## Appeal Decision

**Appeal Ref: APP/R5510/D/23/3329794**

**35 Newcroft Close, Uxbridge UB8 3RH**

FIRST ISSUE			
ISSUE	DATE	INITIALS	GRID REF
A	070323	AT	
PROJECT			
35 NEWCROFT CLOSE UXBRIDGE UB8 3RH			
DWG TITLE			
ELEVATIONS			
CLIENT			
MR. RAJIV KUMAR			
DWG NO:		ISSUE	
TRICON/35NC/104			A
SCALE	DATE	DRAWN BY	
1:100@A3	07 MAR	AT

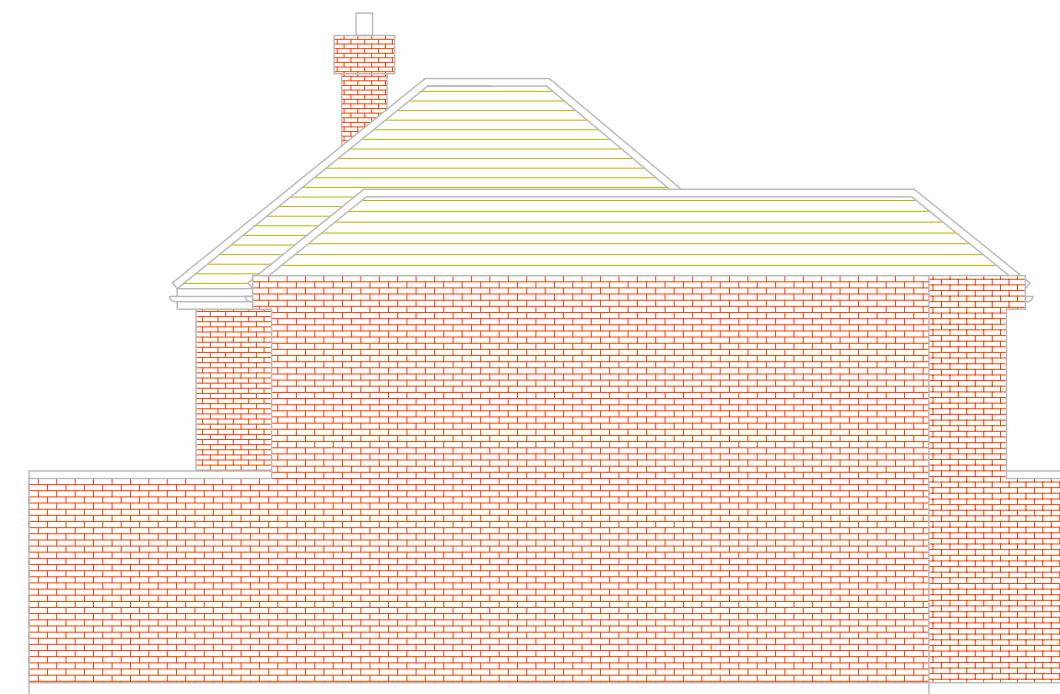
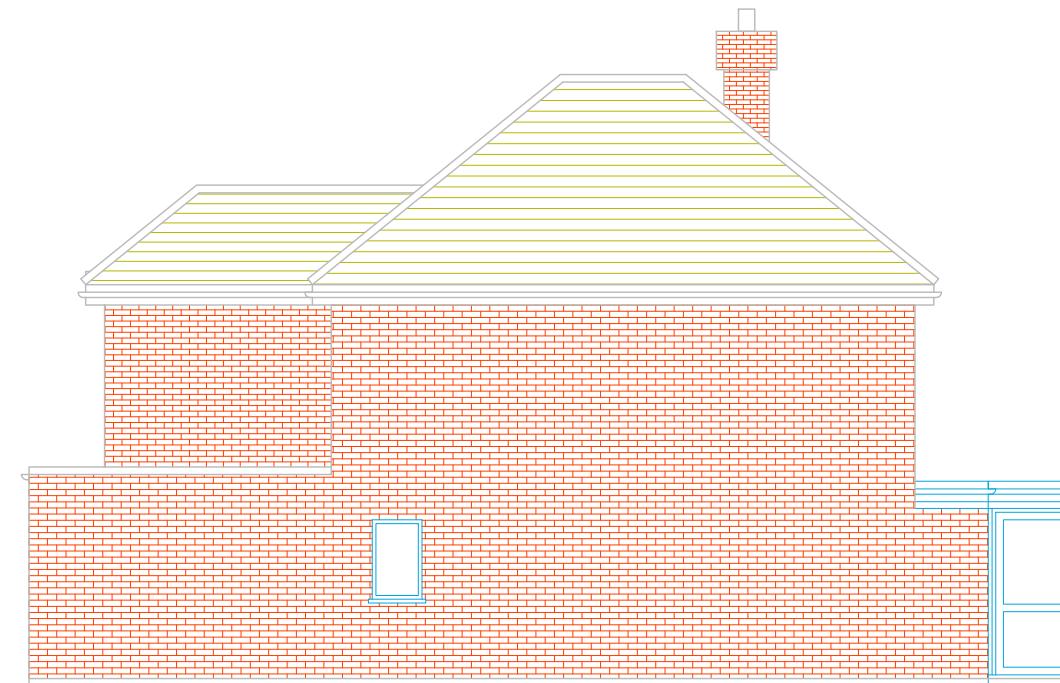
8. The rear extension would be largely at a single storey level, with a narrower second storey extension running out to the rear from the side extension. From the principal elevation, I consider the overall effect would be limited as much of the bulk of the development would be focussed to the rear.

9. The council argue that the use of a crown roof (for the side extension) would add bulk and massing, resulting in harm to the character of the area but I do not agree. I consider it would be very difficult to discern significant bulk from the front or the rear of the appeal dwelling as a result of the proposed design. I therefore do not agree that the proposals would be 'top heavy' as is the case made by the council.

10. I note that the concerns the council also raise include the effect of 'terracing' between properties along this part of the street, caused by the closure of a gap between No's 35 and 37. However, as the neighbouring property at No 37 already has a single storey garage to the side, this, in my view would preserve a gap between the dwellings, such that I do not agree the extension would result in unacceptable enclosure within the street scene.

11. I therefore do not consider that this would result in harm to the character and appearance of the host dwelling or wider streetscene. There would, in my view, be no offence to policies DMHB11, DMHB12 or DMHD1 of the LP2.
